**APPLICATION BY NORTH FALLS OFFSHORE WIND FARM LIMITED  
FOR AN ORDER GRANTING DEVELOPMENT CONSENT FOR THE NORTH FALLS OFFSHORE  
WIND FARM PROJECT  
(REF: EN010119)**

**DEADLINE 2**

**SUMMARY OF WRITTEN REPRESENTATION BY  
THE PORT OF LONDON AUTHORITY**

Deep Water Route Cable Installation Areas (Future Dredging Depths) Plan

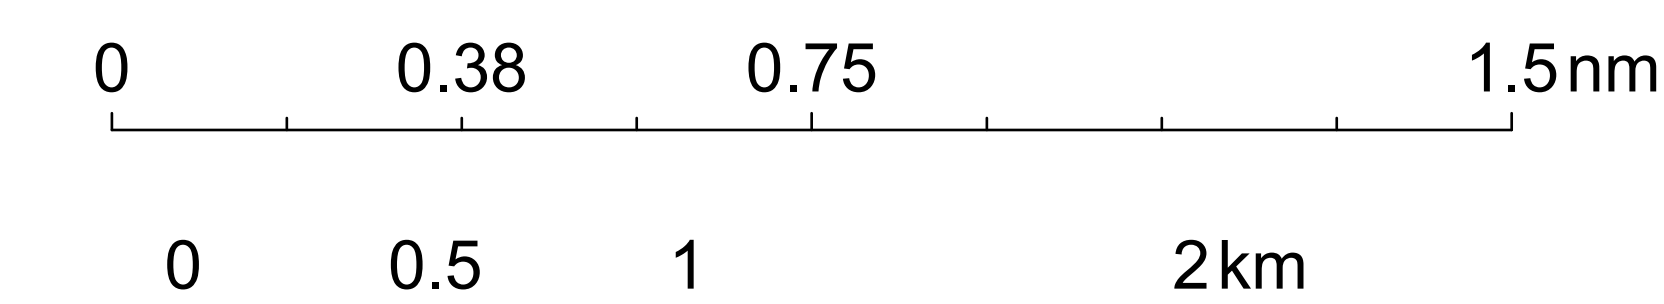
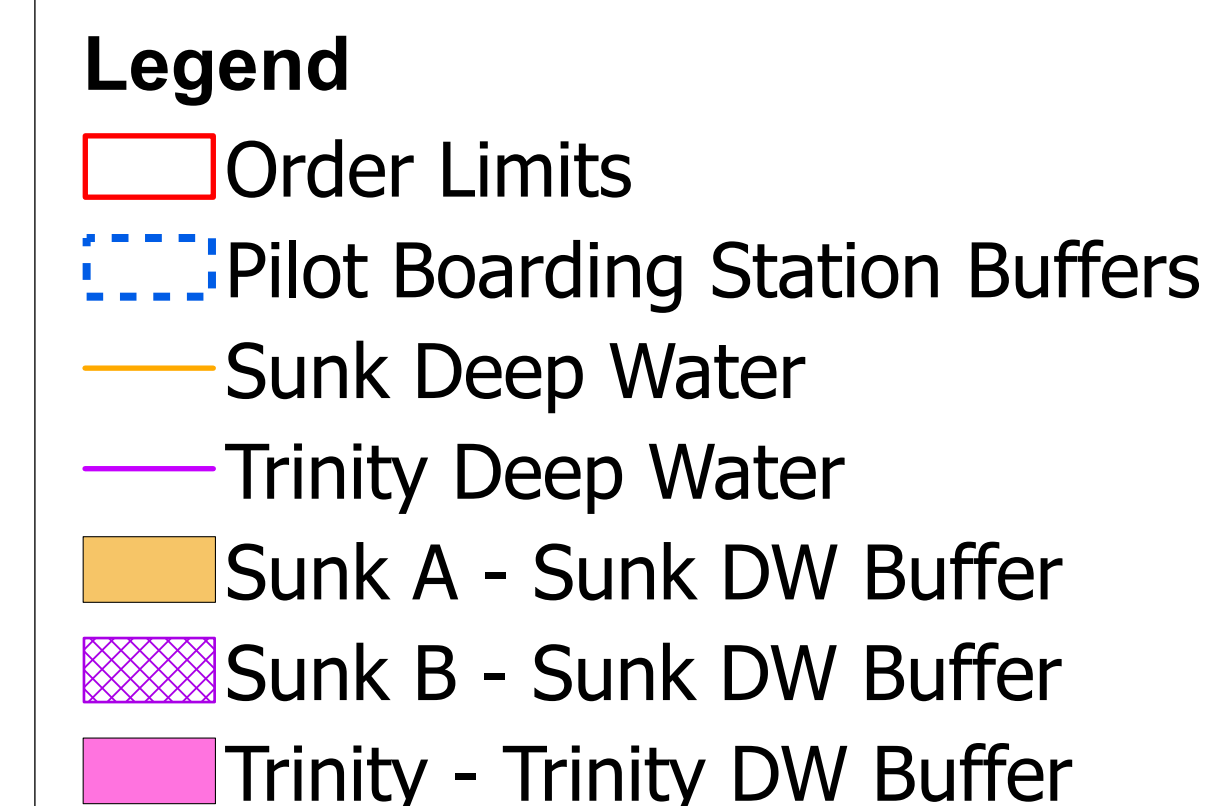
- 3.6 The PLA is unable to agree with this conclusion based on the Application as currently submitted. It has not been demonstrated that the DWRs into the Port have been safeguarded now and into the future and that the cables, cable protection and cable crossings would ensure vessels of 20m draught could enter the Port.

- 4.3 There are areas of the OCC where certainty is required at this stage on cable burial depths, cable protection and cable crossings to ensure that there will be no significant effects on shipping and navigation arising from the OCC, in isolation or cumulatively with other projects, during construction, operation, maintenance and decommissioning. The cables would need to

be installed and maintained within the OCC at a depth that would allow for the Trinity and Sunk DWRs to be dredged and deepened in the future to a depth of at least 22m below CD. This should be secured through a design requirement and a certified plan and an outline cable specification and installation plan should be produced and submitted to the examination which sets out information in relation to cable installation and maintenance, cable crossings, cable protection and temporary works.

*"The undertaker must ensure that in the design, implementation, operation and maintenance of the authorised development and ancillary works, a dredged depth of the Deep Water Routes to a depth of 22 metres below Chart Datum is not precluded or impeded." ("the Requirement")*
